CITY OF ALBUQUERQUE

*Planning Department
Transportation Development Services Section*

Re: Certification Submittal for a Permanent Building Certificate of Occupancy (C.O.)
for **Sawmill Senior Housing**, [H-13 / D025B]
990 18th St. NW
Architect's Stamp Dated 12/22/10

ARCHITECTURAL SITE PLAN

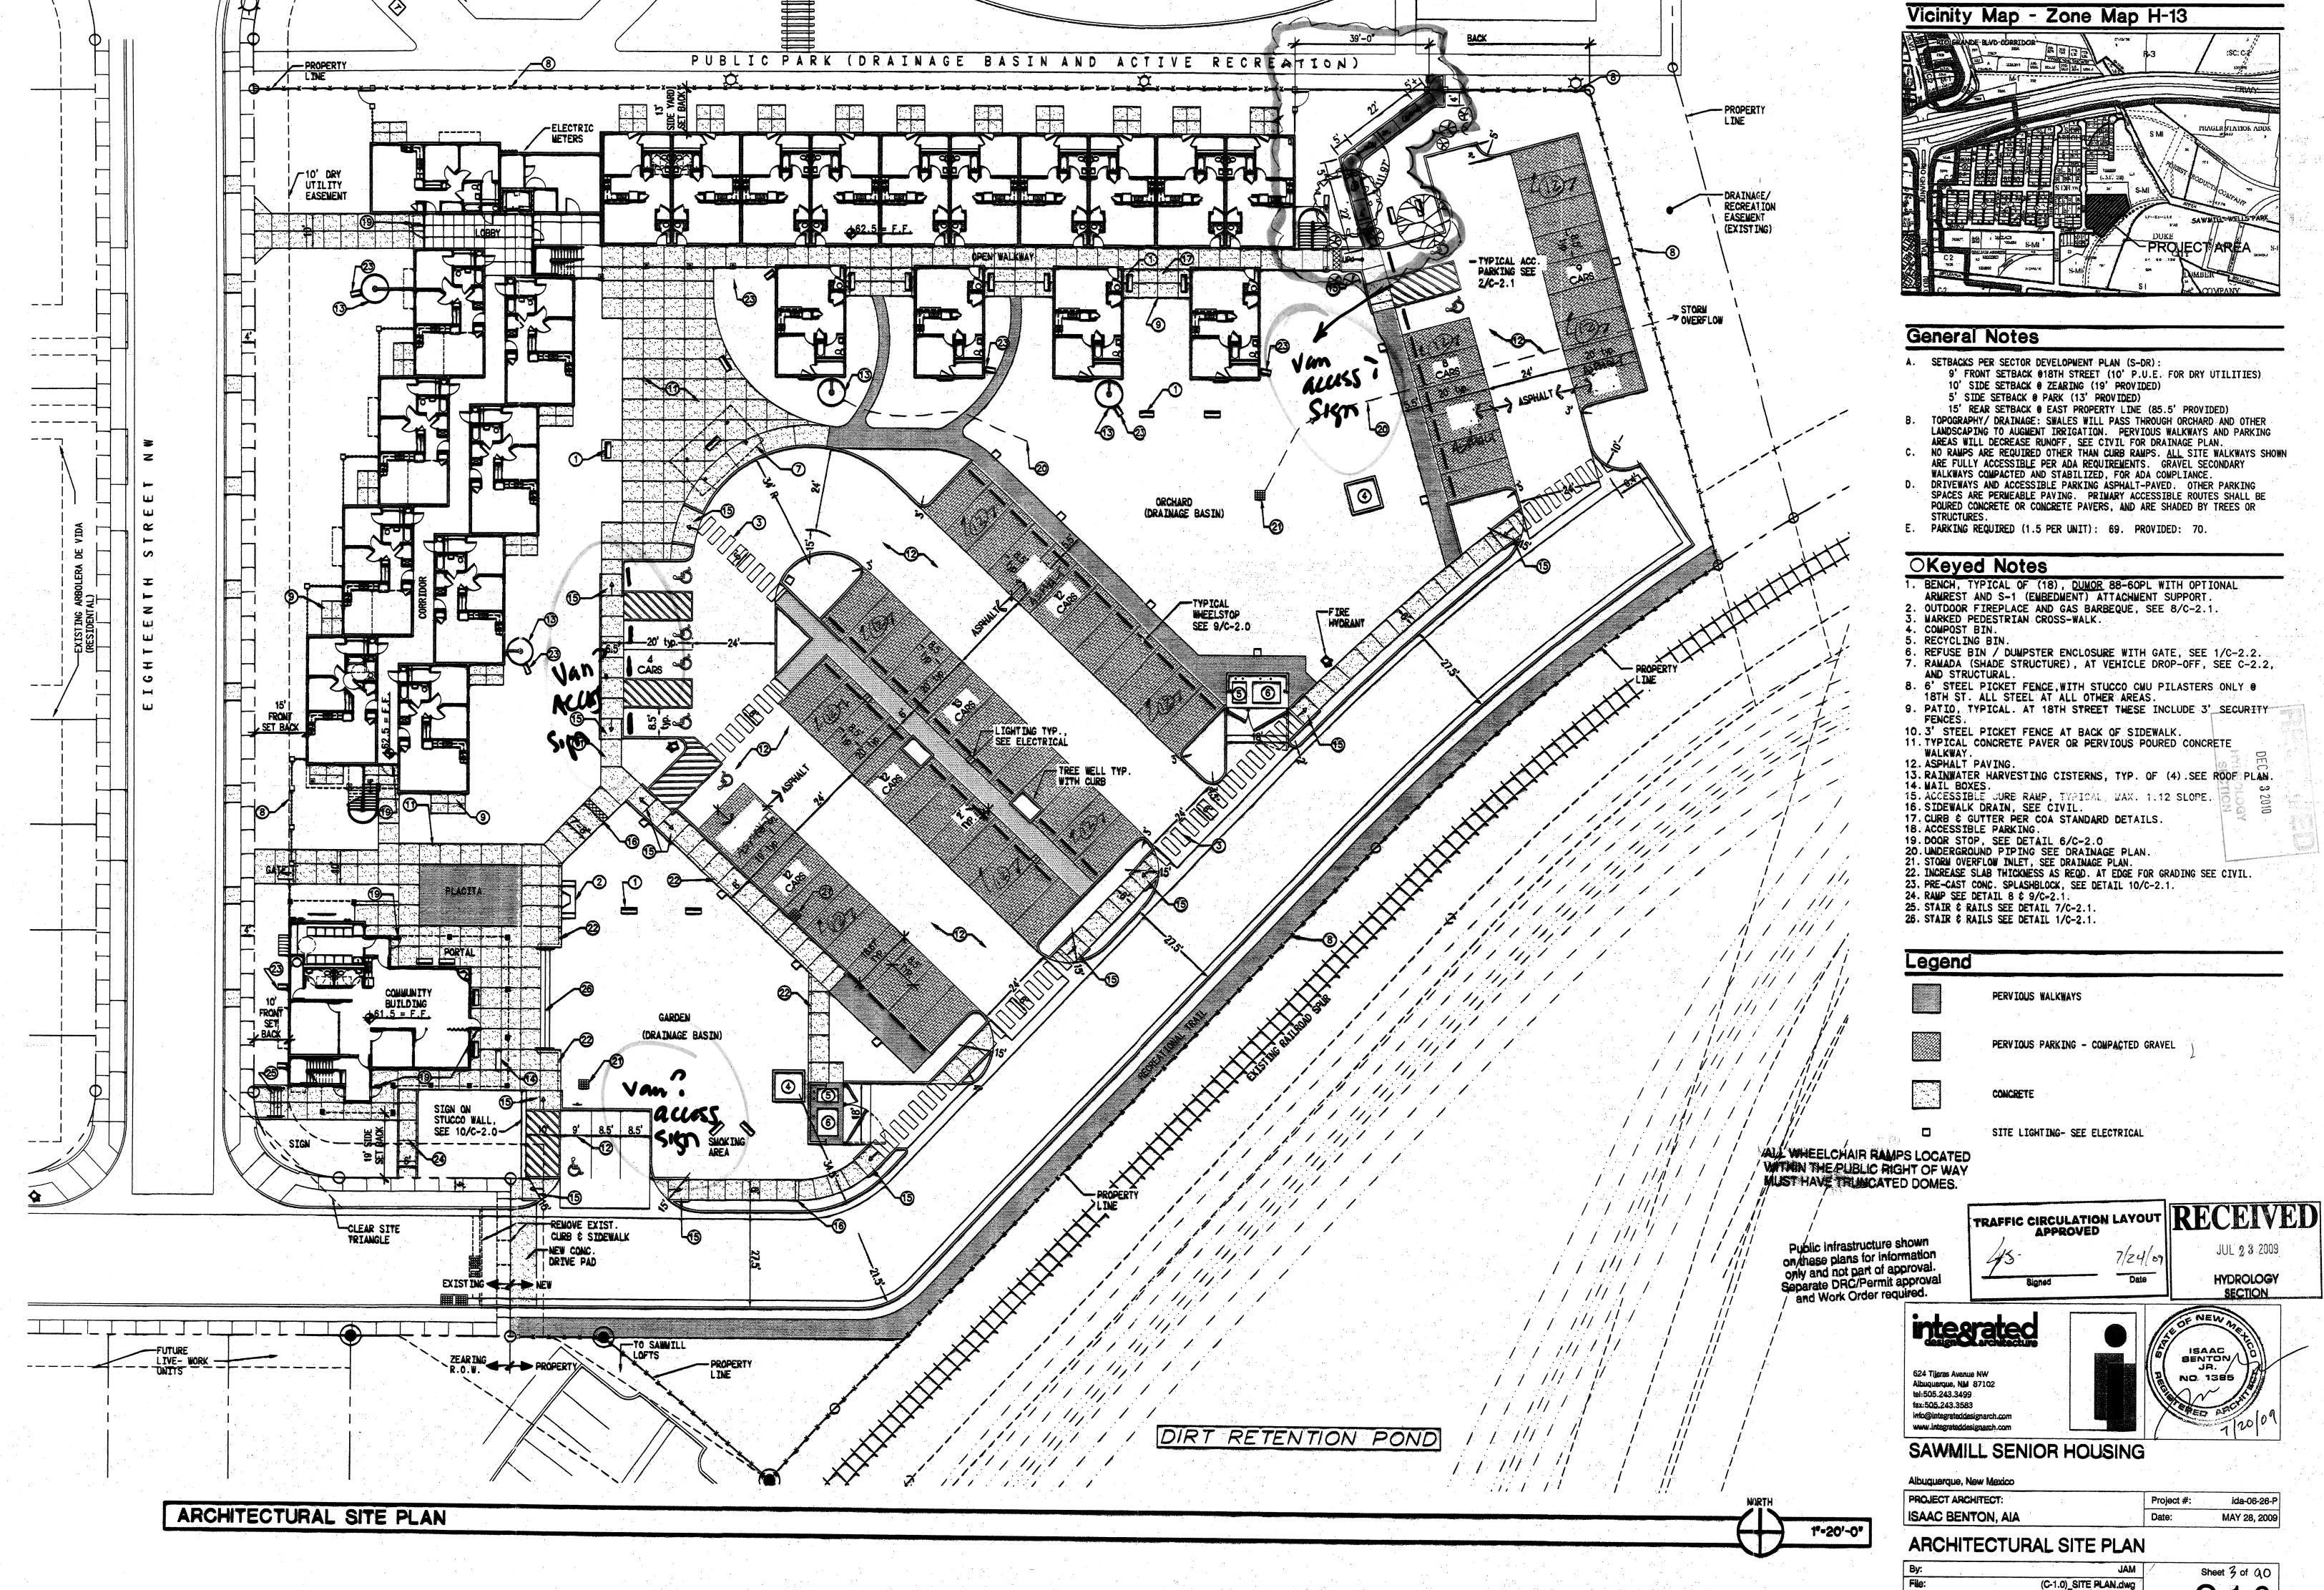
The following items will need to be addressed prior to issuance of a Permanent Certificate of Occupancy: Missing bumpers and Van accessible plate for the van accessible stalls.

The following items will need to be addressed prior to issuance of a Permanent
and/or Temporary Certificate of Occupancy: The drive aisle must be asphalt as shown on
the approved Site Plan dated 07/24/09; the parking stall must be a hard surface (asphalt,
minimum 2 inches) per the City of Albuquerque Comprehensive Zoning Code.

The permeable paving/crushed gravel parking spaces have been replaced with asphalt paving, as required by the City of Albuquerque subsequent to their original approval of the TCL. In my opinion, our original design for pervious, well-compacted $\frac{3}{4}$ " to 1" crushed gravel should in the future be reconsidered by the City Engineer as "equivalent" to 2" asphalt in this type of project and use. Other pervious systems are not affordable for this type of client.

The van accessible plates have been installed for all van accessible spaces and the missing parking bumpers have been installed per City of Albuquerque letter dated December 23, 2010.
